Alexandria Park Community School Redevelopment-Mod-2 (SSD-8373-Mod-2)
Request for Additional Information

I refer to Assessment for the Alexandria Park Community School Redevelopment-Mod-2 (SSD-8373-Mod-2). After careful consideration, the Department is requesting that you provide additional information.

Figure 4 Proposed Sports Field Layout Amendments

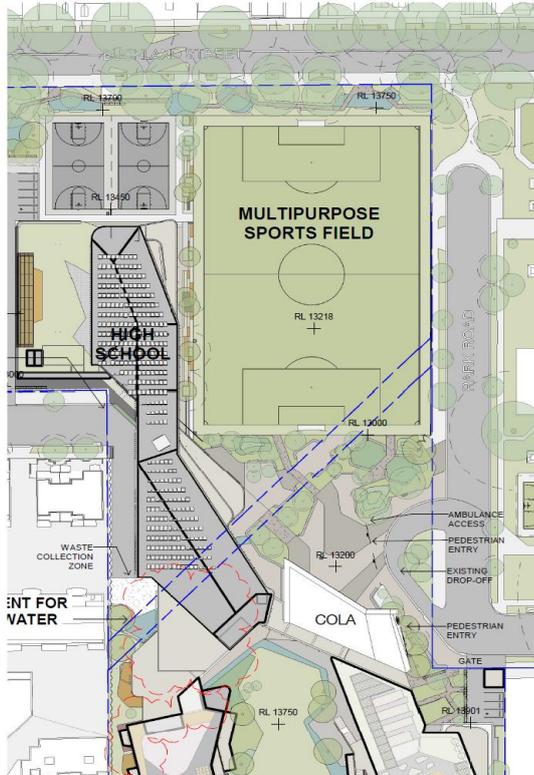
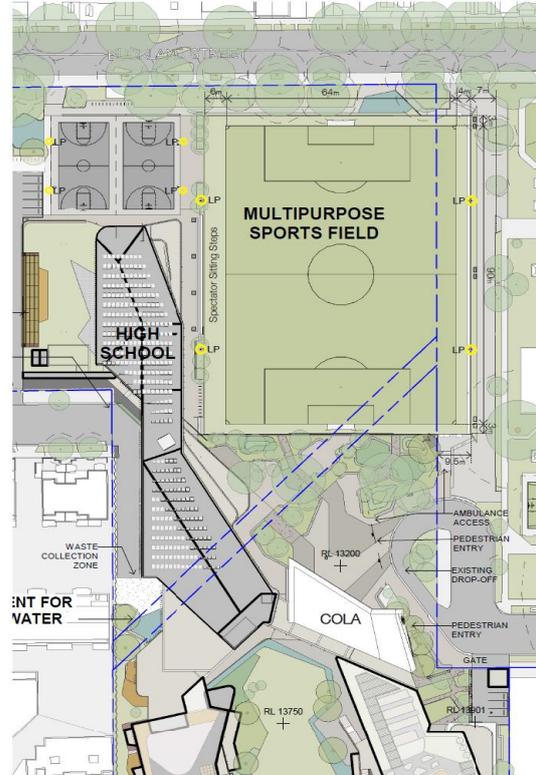
The Department notes a discrepancy between the submitted Environment Assessment Report (EAR) and *Arboricultural Impact Assessment and Tree Management Plan (Redgum, 2020)* (AIM) with the EAR identifying an extra tree for removal – a mature curtain fig (tree 109).

The Department is concerned the Modification's additional tree removal constitutes a significant increase in tree canopy loss at the site, particularly along the eastern boundary and interface with Alexandria Park. Identified as trees 104-109 on the AIM, these species are an important part of the urban canopy that connects the site with species that bound Alexandria Park Tennis and Basketball Courts. Their removal is considered to significantly reduce the tree canopy in this area, reducing shade for future users and spectators of the new sports field and users of the Park Road shared pedestrian zone. The AIM states:

The Department is concerned that the tree loss will pose significant interim and potentially permanent amenity impacts for users of the new sports field and Alexandria Park in this area. Further, it is considered the net reduction in tree canopy does not align with current state and local government strategies that aim to protect and increase canopy coverage across Greater Sydney.

- proposed tree planting locations in the site.
- the discrepancy between the tree loss assessed in the AIM and the EAR.
- opportunities for increasing the tree canopy across the site and adjacent Alexandria Park to compensate for the loss of tree canopy at the site.
- alignment of the project with key State and Local Government strategies to increase tree canopy coverage in Greater Sydney.
- the modification's increased biodiversity impact does not require assessment in a biodiversity development assessment report under section 7.17 of the BC Act.
